SOCIAL IMPACT ASSESSMENT COMMENTS

Department's Review of the Social Impact Assessment (SIA) Scoping Report and Recommendations for the EIS SIA

This review considers the SIA Scoping Report prepared for the Glendell Continued Operations Project (Umwelt, May 2018) prepared in accordance with the Department's new *Social impact assessment guideline for State significant mining, petroleum production and extractive industry development* (SIA guideline) The SIA Scoping Report is provided as Appendix A of the project's Preliminary Environmental Assessment.

FIGURE 4.3

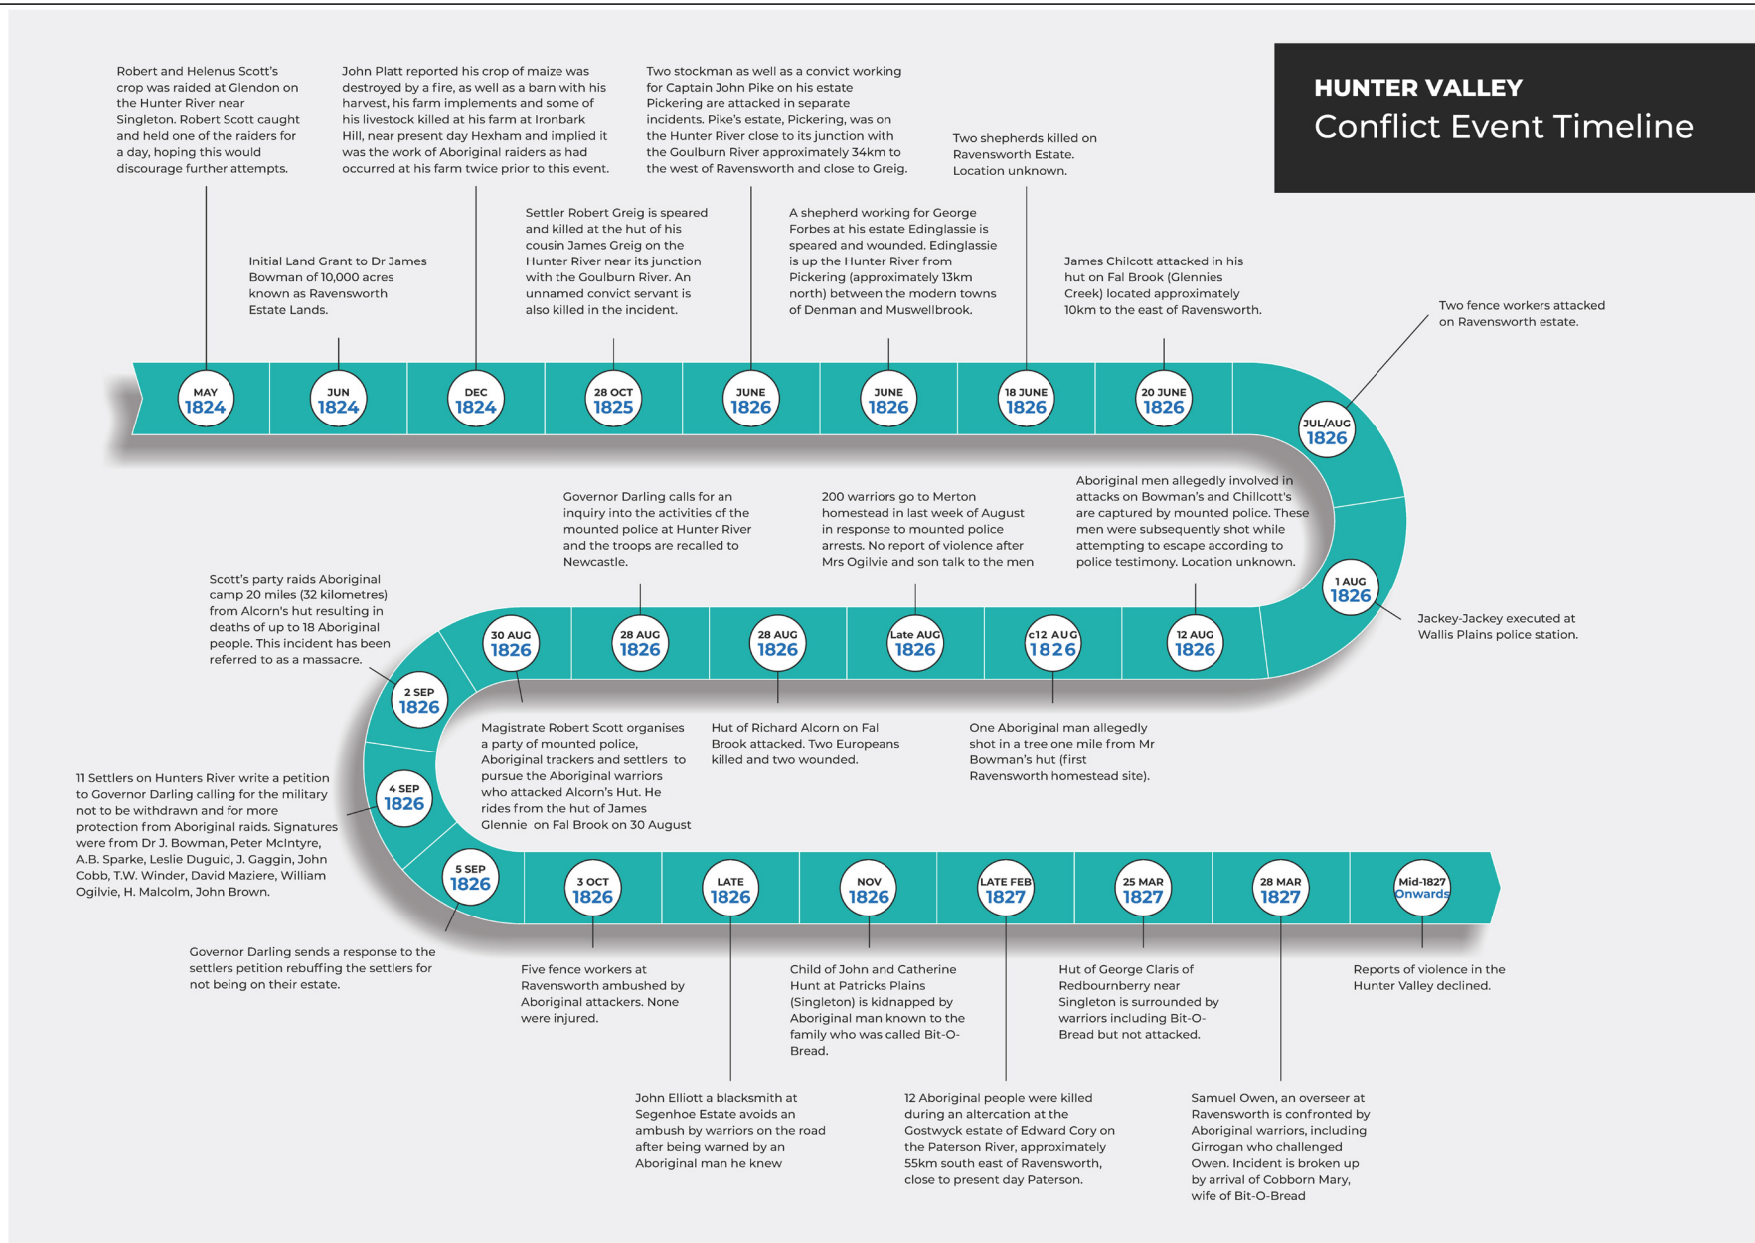
<p>issues would assist in integrating and understanding current and predicted social impacts.</p> <p>Some inconsistencies are also noted between the issues of greatest significance in Figures 4.2 and 4.3 and those discussed in greater detail in Sections 4.2 and 4.3. Land Management appears to be of lesser concern than Health and Wellbeing impacts, yet the latter are not discussed and analysed. These adverse impacts and high-level community concerns need to be addressed directly in the SIA for the EIS.</p> <p>In the analysis of issues, the SIA for the EIS should also include evidence to substantiate or question the identified issues and perceptions. Comments about feared depreciation (or increases) in property values should be supported by data. Statements from community members about experiences in dealing with Glendell staff should be analysed to determine why some issues or stakeholders appear to receive different responses or treatment to others, and whether there are opportunities to improve performance through mitigation measures, if this project is approved. Health data and evidence should be analysed and included in the SIA for the EIS.</p> <p>Statements about the possible future relocation of Ravensworth Homestead imply that this option is likely to proceed. Other options do not appear to have been given equal consideration.</p> <p>Cumulative social impacts should be considered in more detail in the SIA for the EIS. Again, incorporating some of the information from other studies and feedback describing how impacts overlap or compound to affect daily life, activities and values (from the point of view of affected residents, employees and business stakeholders) would provide a deeper understanding of their experiences.</p> <p><u>Recommendations</u></p> <p><i>The SIA for the EIS should:</i></p> <ul style="list-style-type: none"> ➤ <i>Disaggregate and analyse social impacts and benefits by social impact category and according to key stakeholder groups and significance for affected stakeholders.</i> ➤ <i>Use evidence from a range of sources, including from other relevant studies of mining impacts in the region, to substantiate or challenge issues and concerns.</i> ➤ <i>Demonstrate that alternative scenarios for Ravensworth Homestead have been considered and analysed.</i> ➤ <i>Include information on any cultural heritage impacts and health impacts given the poor health indicator scores identified in the Capitals Analysis (Table 3.2).</i> ➤ <i>Consider cumulative impacts from multiple projects or occurring in single locations and across time-frames to understand the full extent of expected impacts.</i>
